98, Elmer Road, Middleton On Sea, Bognor Regis
Proposed Extensions & Alterations & Extended Parking Area
Application No. M/114/17/HH

Further to your e.mail communication dated 14th November 2017 I enclose two copies the following amended information as requested in your e.mial.

General Arrangement Plan ~ As Proposed

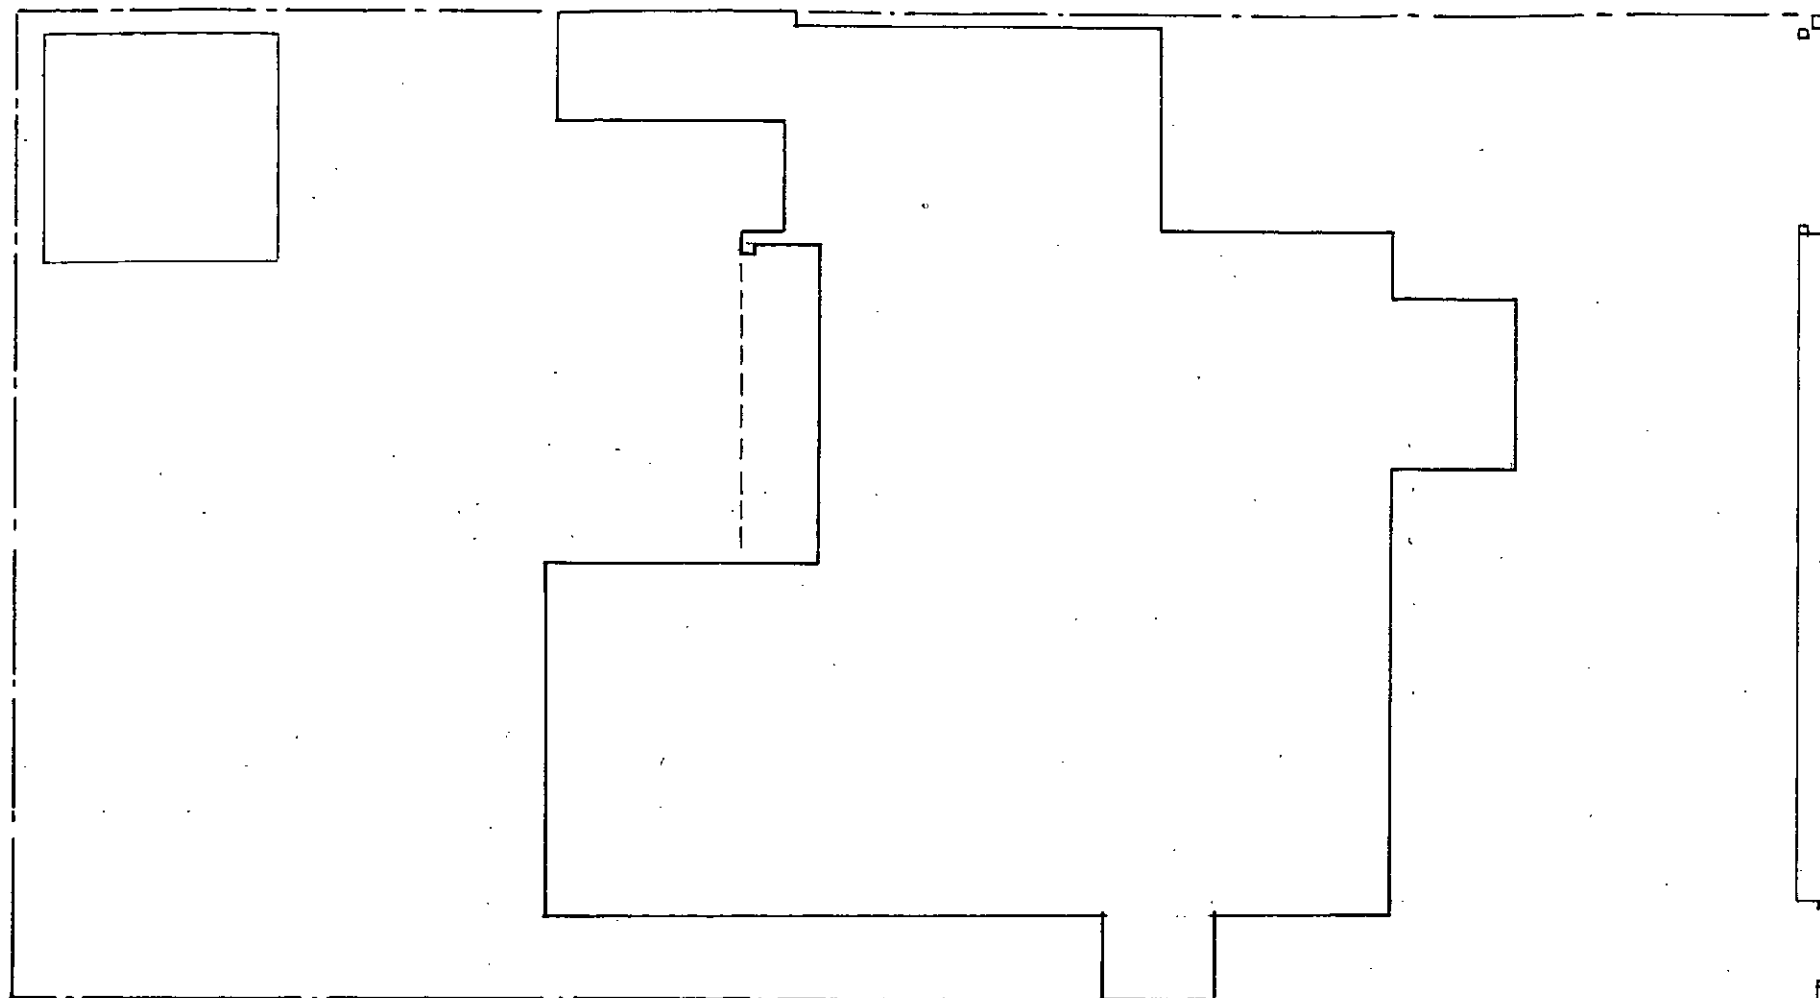
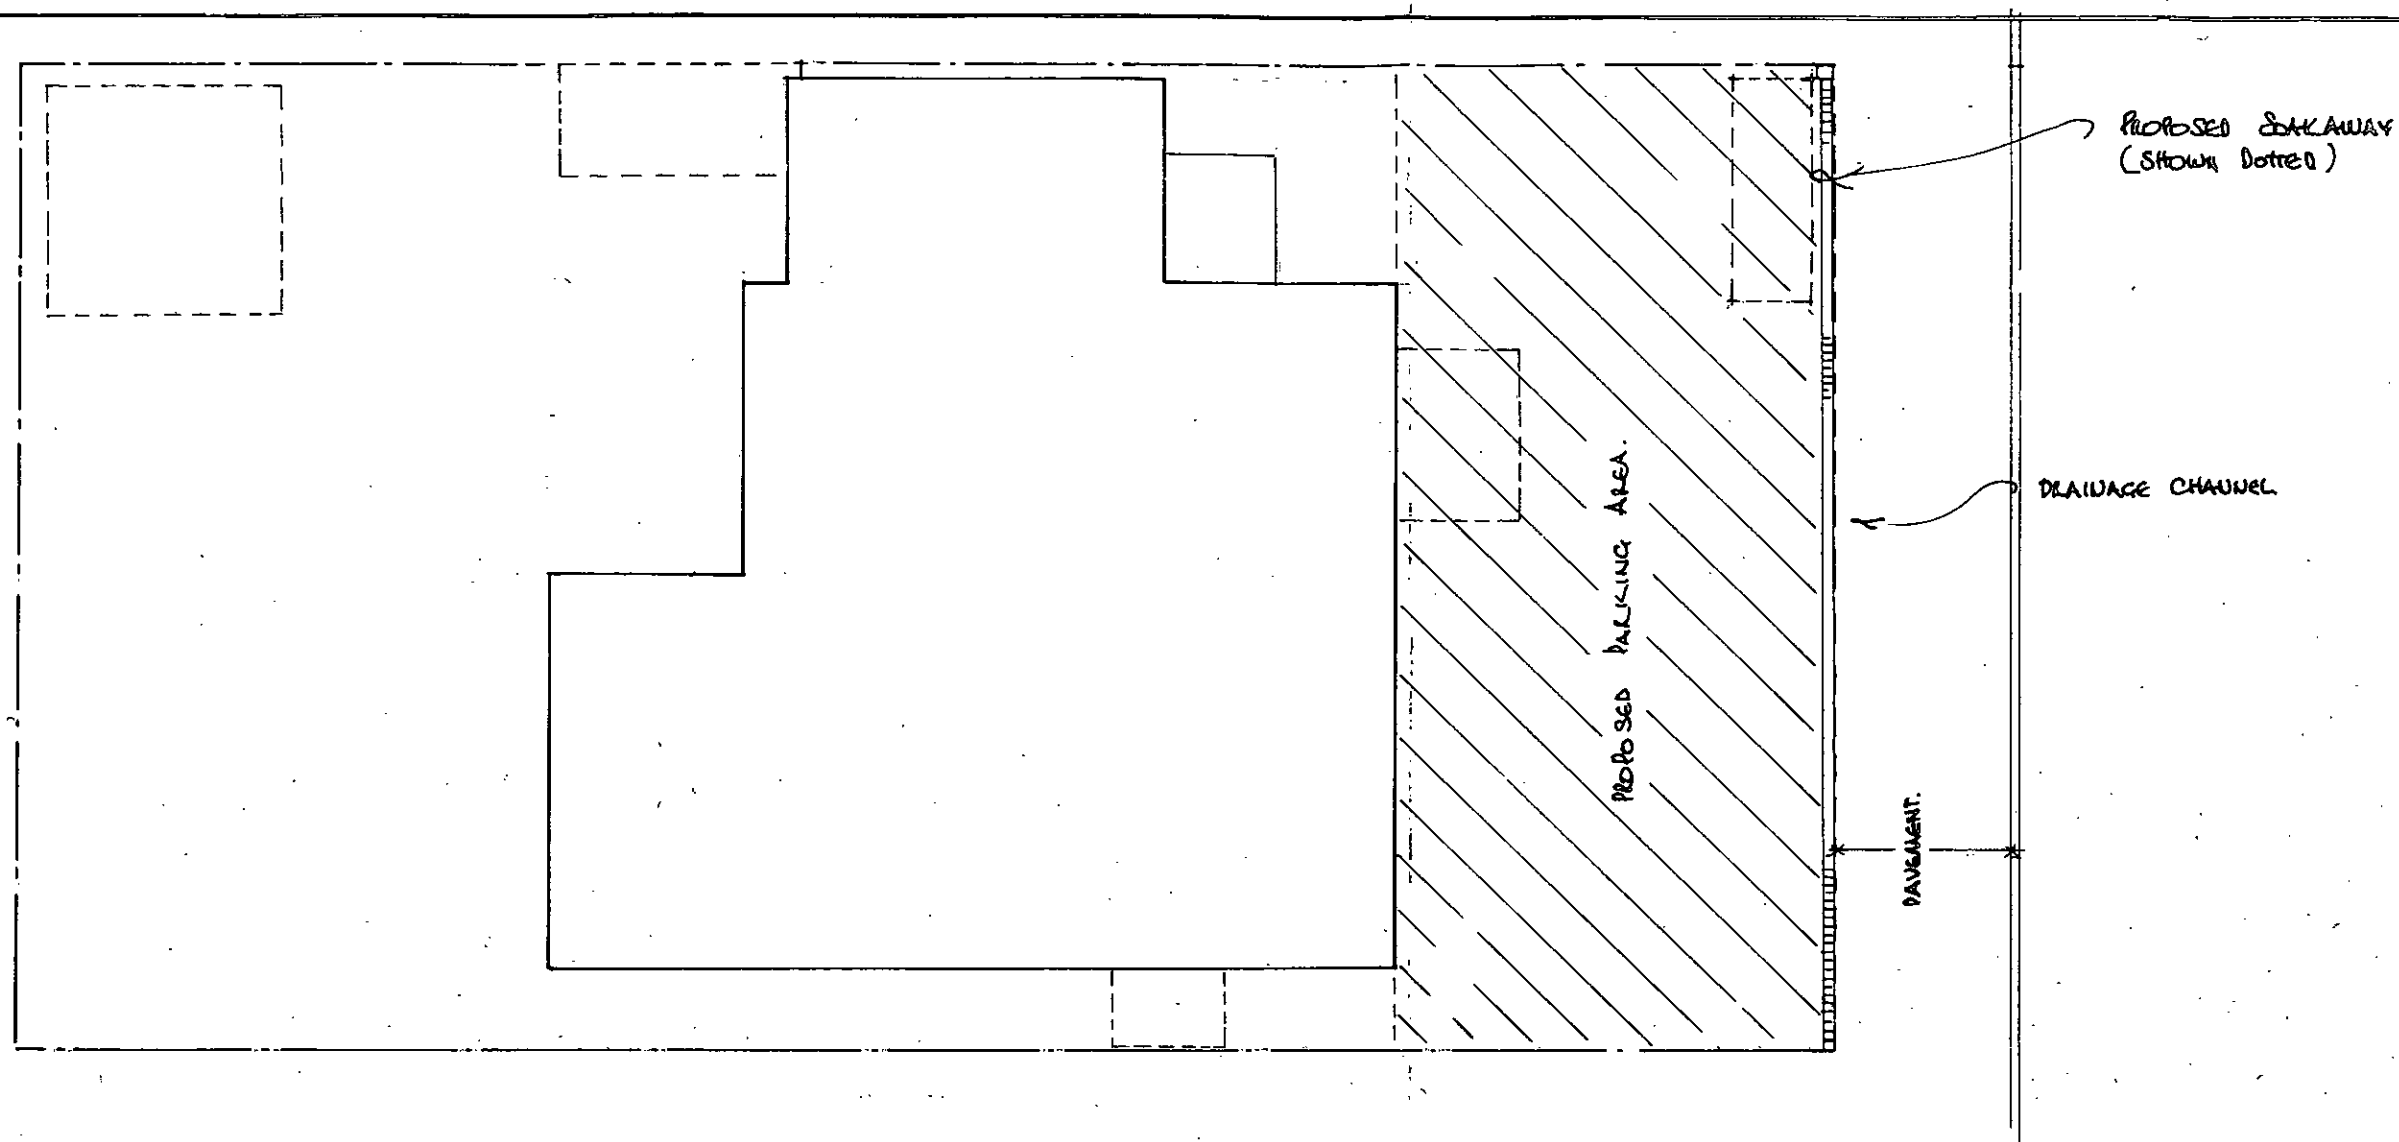
- 1) Block Plans showing distances to boundaries.
- 2) Proposed elevations with the correct orientations added.
- 3) Existing Ground Floor Plan amended with the staircase window shown.
- 4) Proposed ground/first floor plan amended with the staircase window shown.
